## Memorandum ABP-317810 - Request for Further Information under Section 131

**To:** Paul Caprani, ADP  
**From:** Laura Finn, PI  
**Re:** 317810 - Request for Further Information  
**Date:** 7<sup>th</sup> May 2024

- **SITE BOUNDARY**
TOTAL AREA 13.630Acre
(55162.092sqm)
- **OHL** — **OVERHEAD LINES**
- **EXISTING GAS LINE**
- **PROPOSED FENCING TO MATCH EXISTING**
- - - **LOCATION OF PROPOSED ACCESS GATE**
- **ADJOINING LAND IN THE OWNERSHIP/CONTROL OF TYNAGH ENERGY LIMITED**

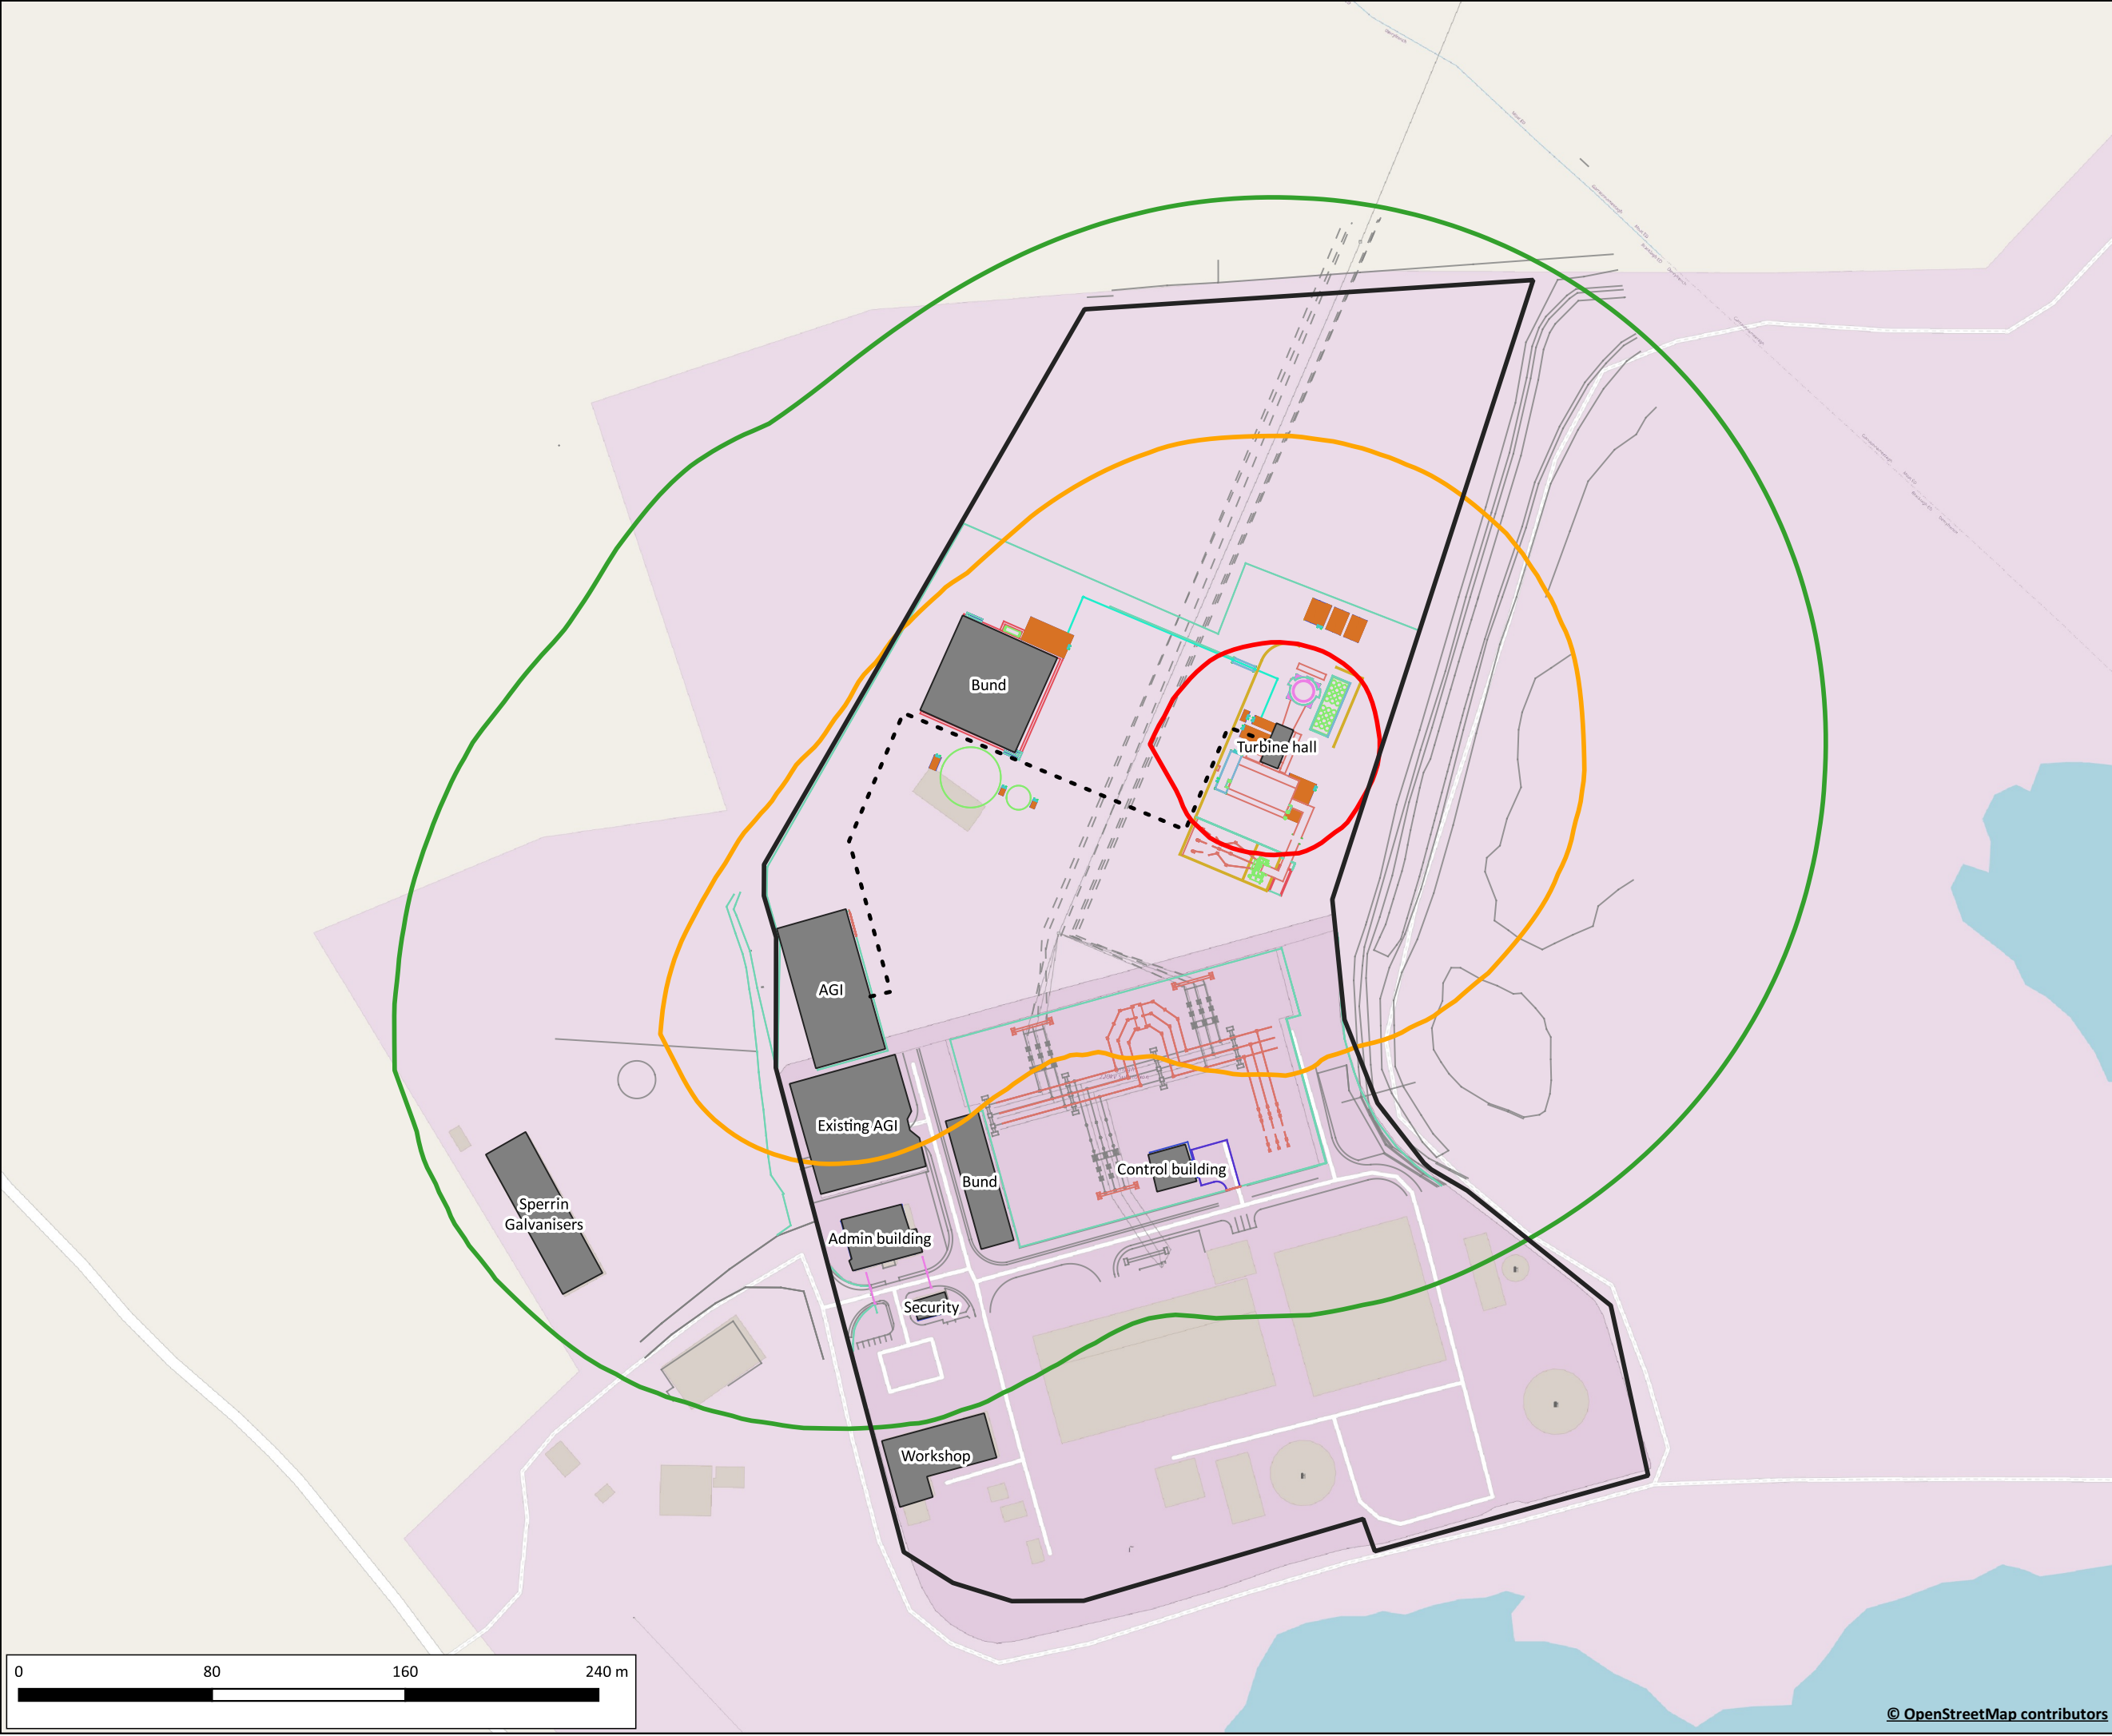
Appendix 1, site layouts. An overall map should be furnished that shows the area that will form the COMAH site boundary and includes:

- a) The existing Tynagh Energy COMAH site
- b) The previously granted Tynagh South COMAH site
- c) The proposed Tynagh North COMAH site'
